16 September 2012

RE. CHURCH OF TWELVE APOSTLES – Retention of Change of Use of land to create extension to existing car park and associated landscaping and vehicle crossover

| Drawing Title PROPOSED EXTENDED CAR PARK AND LANDSCAPING | | |

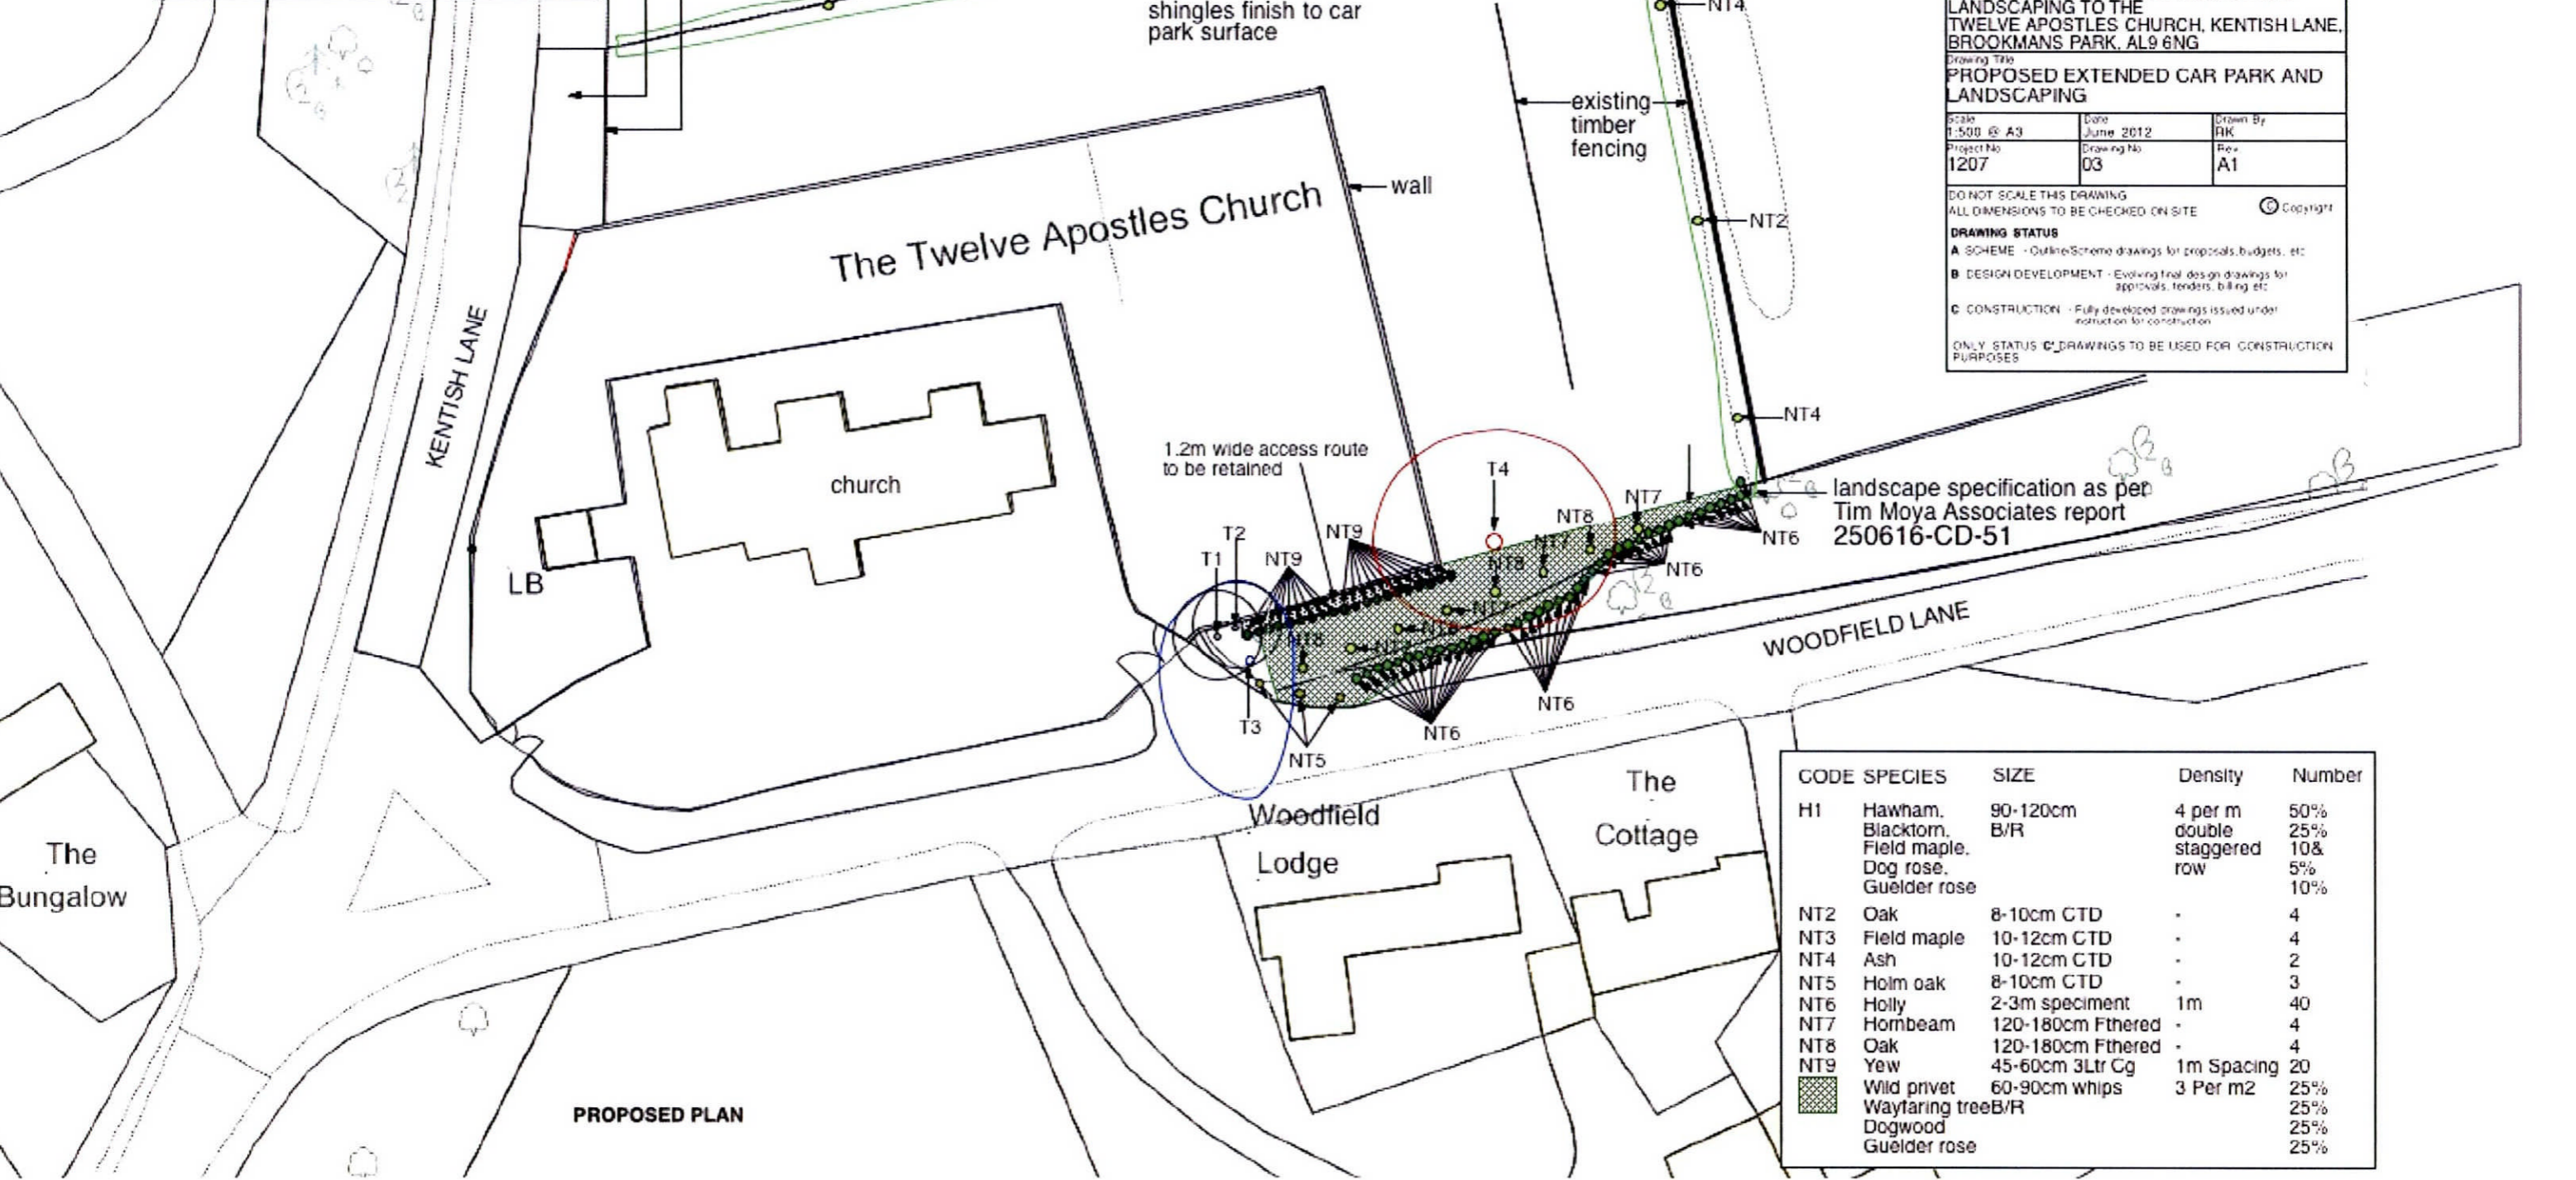
We have studied the revised plans for the extension of the Car Park at the above Church and agree to accept these. Now the Greek community must adhere to them. We did notice that you have not included change of entry to properties opposite the Car Park entrance – The Bungalow, Woodhill Farm and Lakewood House. This is not shown on the map.

We will be keeping a keen eye on the planting of the shrubs and trees and hope that by using yew and holly amongst other shrubs a good screen will be achieved. We did not move into the country to look out on rows of cars. However this will hopefully be moving the cars off the road and will save accidents happening.
